**Consultation Response from KC,
Highways Development Management**

2024/91260 Land at, Merchant Fields Farm, off Hunsworth Lane, Cleckheaton

Variation of condition 2 (plans and specifications) and 35 (removal of permitted development rights) of previous permission 2021/92801 for erection of 291 dwellings with associated works and access from Hunsworth Lane and Kilroyd Drive – revisions to house types, unit size mix and layout

Recommendation – Further information required

status: PLANNING
 project: MERCHANTS FIELD CLECKHEATON
 site: SITE LAYOUT
 drawn: QYRB. date: MAY 2019
 checked: RB. scale: @ A0:1:500
 job no: 122. dsg no: 122-PL-01-V

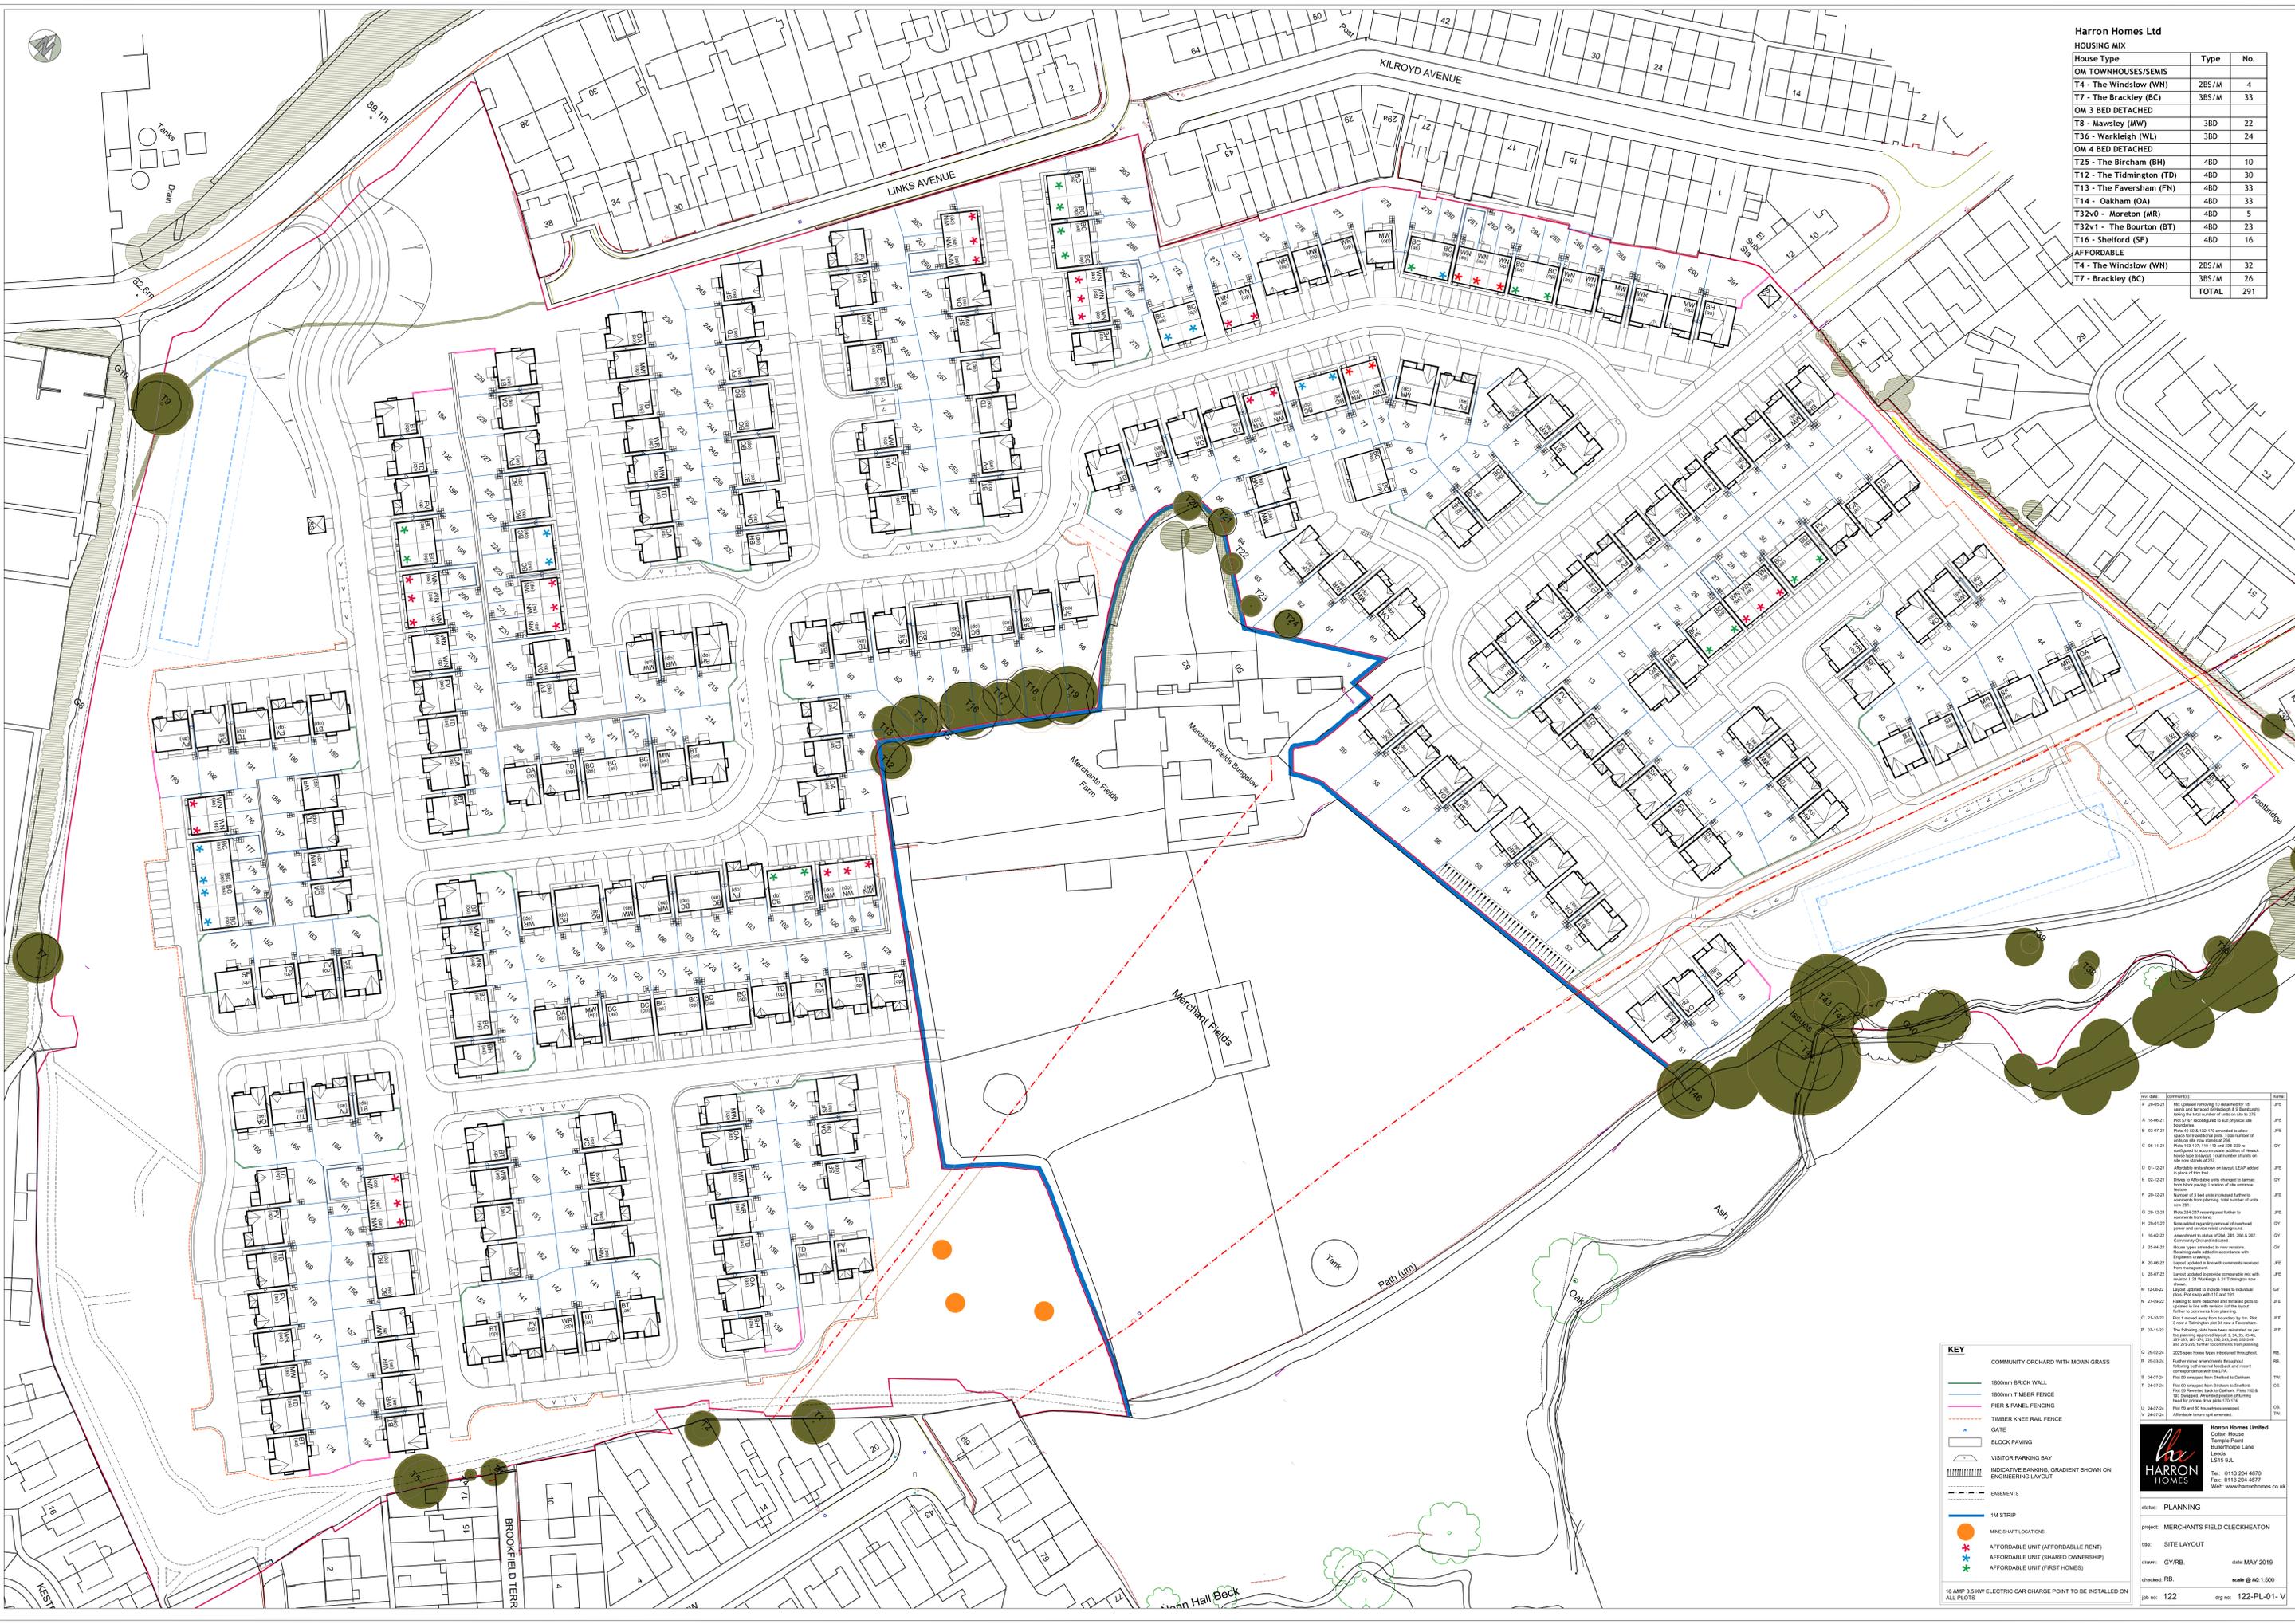
Forward visibility around the bends adjacent to plots 12 and 254 cuts across the curtilage of the properties. Forward visibility must be provided within the highway boundary, widen footway/carriageway to accommodate forward visibility splay.

Visibility splays at the junctions adjacent to plots 60 and 68, and 71 and 291 incorrectly drawn amend accordingly with splay measured from centre of carriageway.

All private drives must identify a suitably positioned bin collection point adjacent to the adopted highway – amend accordingly.

Vehicle tracking swept paths show numerous locations within the layout where the waste collection vehicle overhangs the carriageway, extending over the footway and parking areas. Amend layout and demonstrate that all turning movements can be accommodated within the carriageway.
